Planning Application No: 3/2021/0078

[REDACTED]. The rear of our house in Laneside Close is facing directly into some of the rear gardens in Beech Drive. In our case our property looks towards the garden of number 28 Beech Drive.

PROPOSED REAR (W) ELEVATION
Scale 1:50

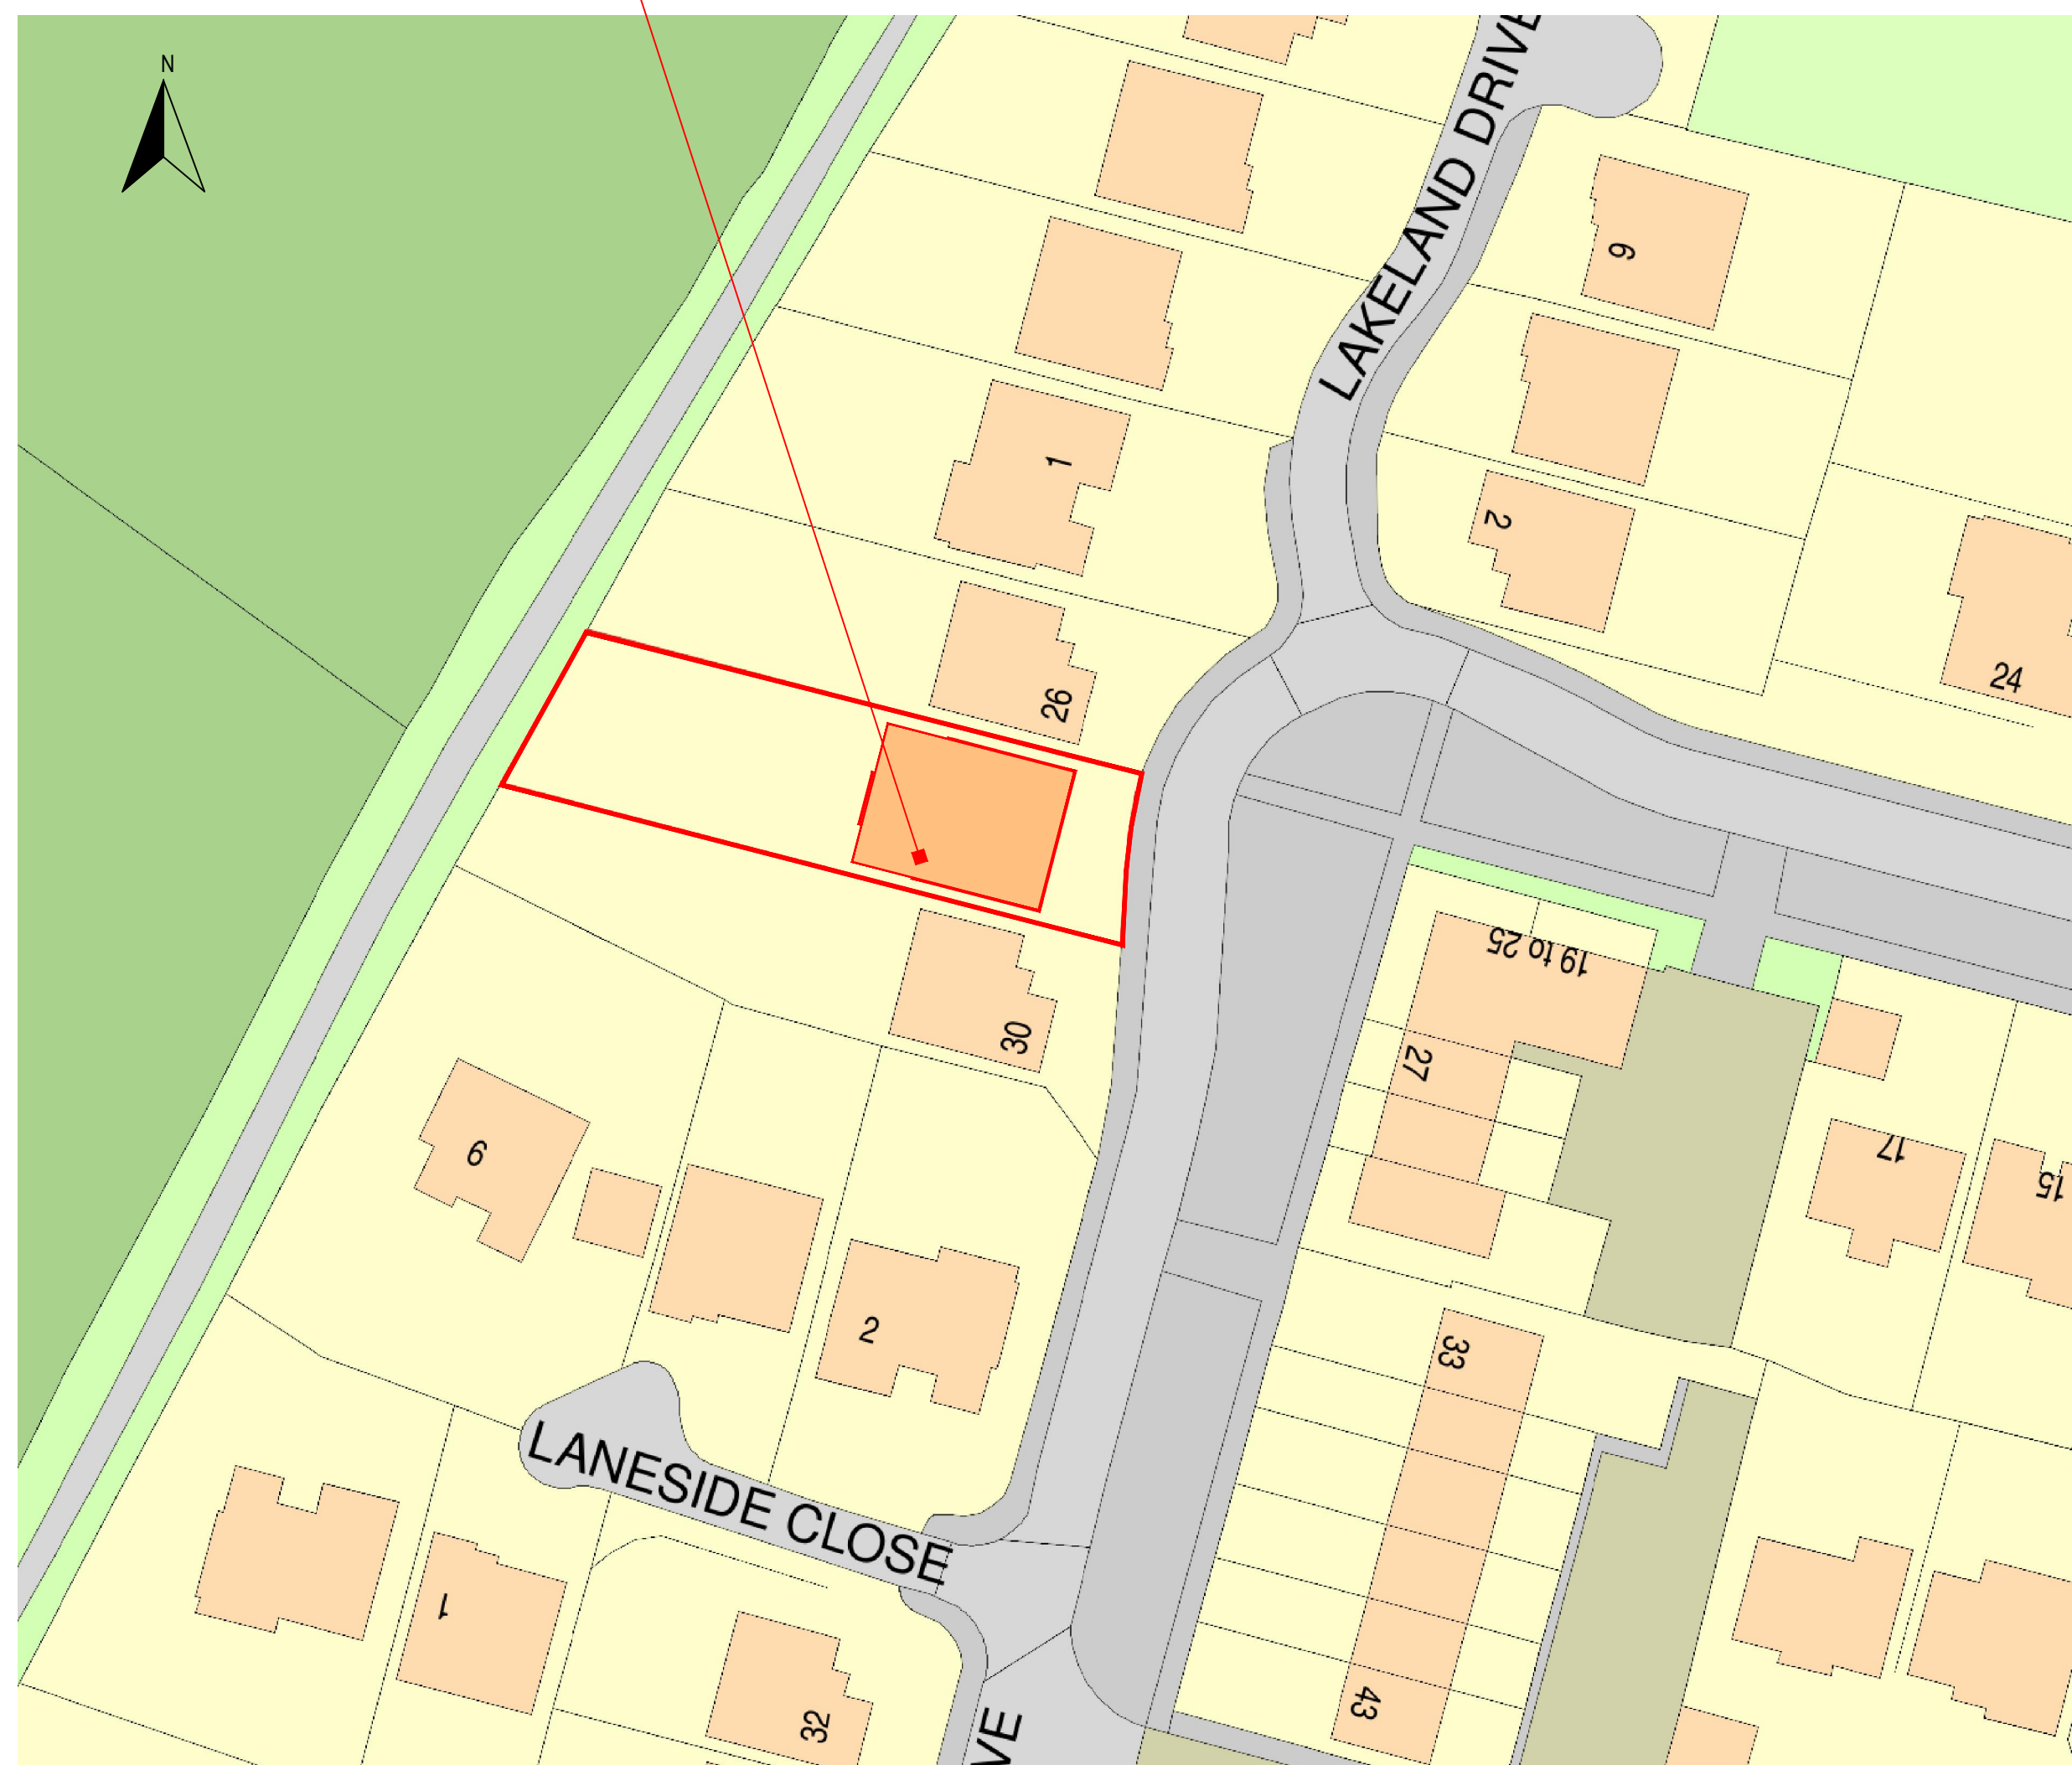
The planned roof terrace on the first floor would allow the residents of 28 Beech Drive to overlook our whole garden from the front of their terrace. We would feel a massive loss of privacy due to this.

At present we have an open view out of our windows at the back of the house and from our garden area. If the application goes ahead and they would build a brick wall with an additional roof terrace it would strongly influence our existing view, specially from the living room, in a negative way.

After reviewing the plans, the extension is grossly oversized compared to all other extensions on the estate. Not only it is the full width of the back of their house, but also two floors which includes the roof top terrace. An extension of this size would be out of proportion with other extensions on the estate and extremely overbearing to us and the other neighbours.
